H2Teesside Project

Planning Inspectorate Reference: EN070009

Document Reference: 8.11.1 Response to ExQ1 General and Cross Topic

Date: October 2024

APPENDIX 1: MAP OF INDICIATIVE LOCATIONS EXCEEDING ORDER WIDTH

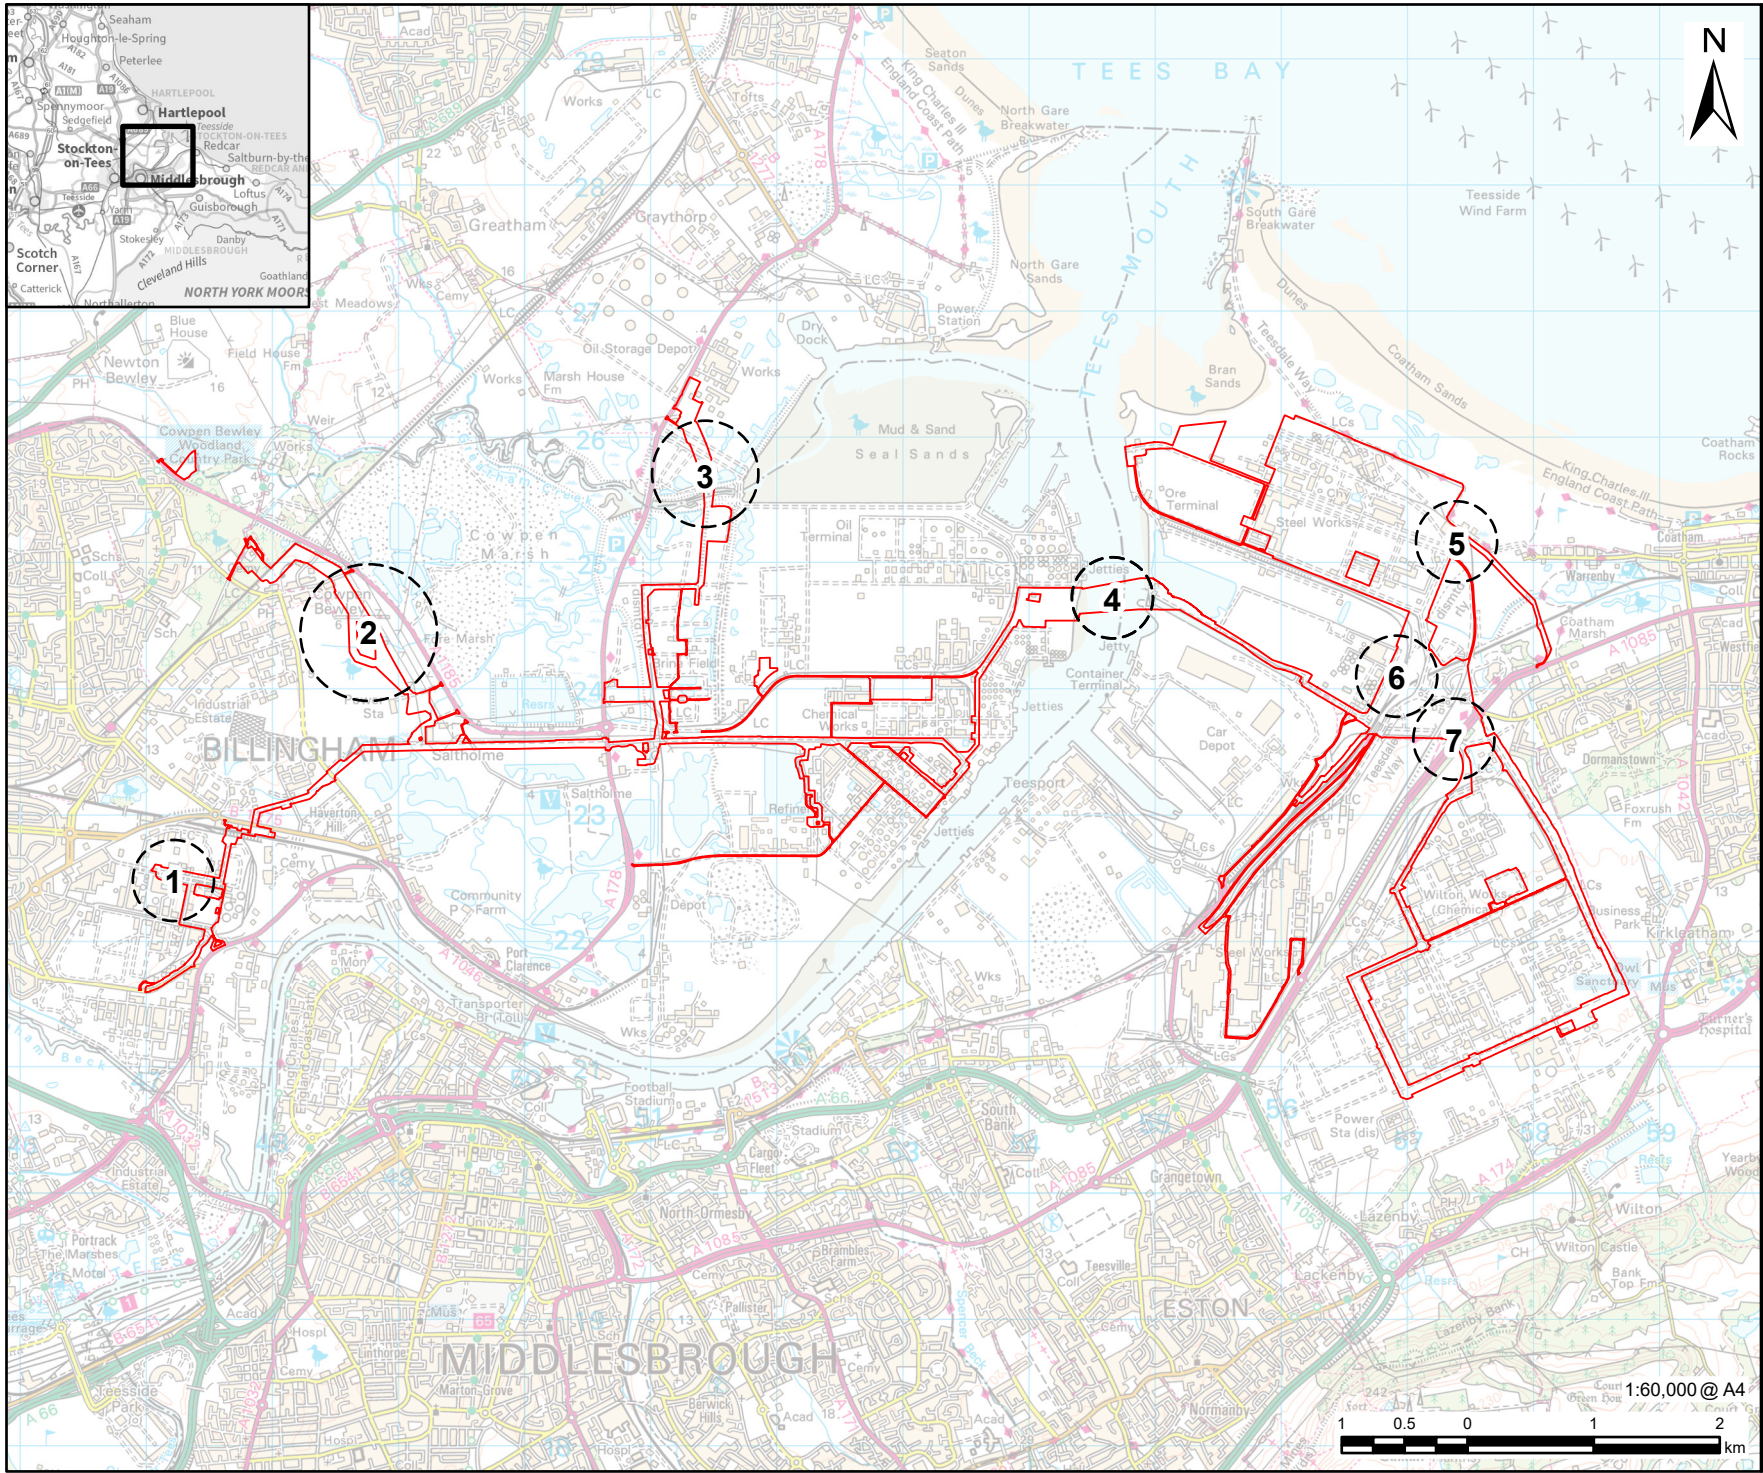
Q.1.1.2	Applicants	<p>Clarification/ Explanation.</p> <p>Is there an optimum or target width of pipeline corridor proposed to establish the Application Boundary? Where this is exceeded, please explain the need for this additional width.</p>	<p>The typical construction width for the buried pipeline is 17m either side of the pipeline, giving a total corridor width of 34m.</p> <p>For buried sections this width allows space for the trench, working area for the pipeline, vehicle and passing lane, and storage areas of topsoil and subsoil. Reducing the width compromises either the safety or efficiency (speed) of construction, as for example excavated spoil must be transported and stored elsewhere, then later returned.</p> <p>For above ground corridors, the width is primarily dictated by the existing corridor width. Typically, this includes fencelines, existing pipelines and supports, and a service lane. The Order limits include the entire width of the existing corridor rather than 17m either side of the proposed pipeline as the location of the proposed pipeline relative to the existing pipelines may change over the course of the design phase. An example of a change would be to move the proposed pipeline from one side to the other side of the pipeline corridor for space reasons. This would be developed in conjunction with the asset owners, pursuant to their Protective Provisions to ensure the most appropriate construction methodology and design, accounting for their specific safety and operational requirements.</p>

EXQ1	QUESTION TO:	QUESTION:	APPLICANT'S RESPONSE
			<p>Some areas exceed the typical width for location-specific reasons. These are summarised below, and are explained in more detail in the Order Width Limit Explanatory Note submitted at Deadline 2 alongside this document (Document reference 8.13):</p> <ul style="list-style-type: none"> • Installed by HDD: <ul style="list-style-type: none"> ○ Tees Crossing ○ Greatham Creek Crossing • Design uncertainty due to 3rd parties: <ul style="list-style-type: none"> ○ Cowpen Bewley pipeline corridor ○ Bran Sands Corridor ○ NZT/NEP approach corridor • Constructability constraints: <ul style="list-style-type: none"> ○ Billingham high pipe racks ○ Wilton congested pipeline corridors
Q.1.1.3	Applicants	<p>Clarification/ Explanation. Please explain if it is necessary for agreements to supply hydrogen to all business areas before installing pipelines to those sites. If so, please outline the status of these agreements, accepting that these may be commercially sensitive.</p>	<p>The Applicant is proposing to construct a hydrogen distribution network that connects the major industrial areas across Teesside, providing industrial consumers with access to low carbon hydrogen as an alternative fuel source or process feedstock.</p> <p>Construction of the Applicant's hydrogen network is based on overall anticipated demand, from:</p> <ul style="list-style-type: none"> • existing industrial consumers; • new organisations looking to develop businesses across Teesside, supporting the Tees Valley Combined Authority ambition "to become the world's first Net Zero industrial cluster by 2040" and create jobs for the ; and • future connections to third party hydrogen transportation and storage developments, including a UK and regional hydrogen transmission system (e.g. 'Project Union') that is being planned to support the UK Government's net zero 2050 target. <p>Prospective consumers will be able to connect to the proposed hydrogen network throughout the life of the Proposed Development.</p> <p>The Proposed Development does not require agreements to supply hydrogen to all business areas before installing pipelines to those sites – it is creating a network to facilitate conversion to hydrogen across a cluster location (i.e.</p>
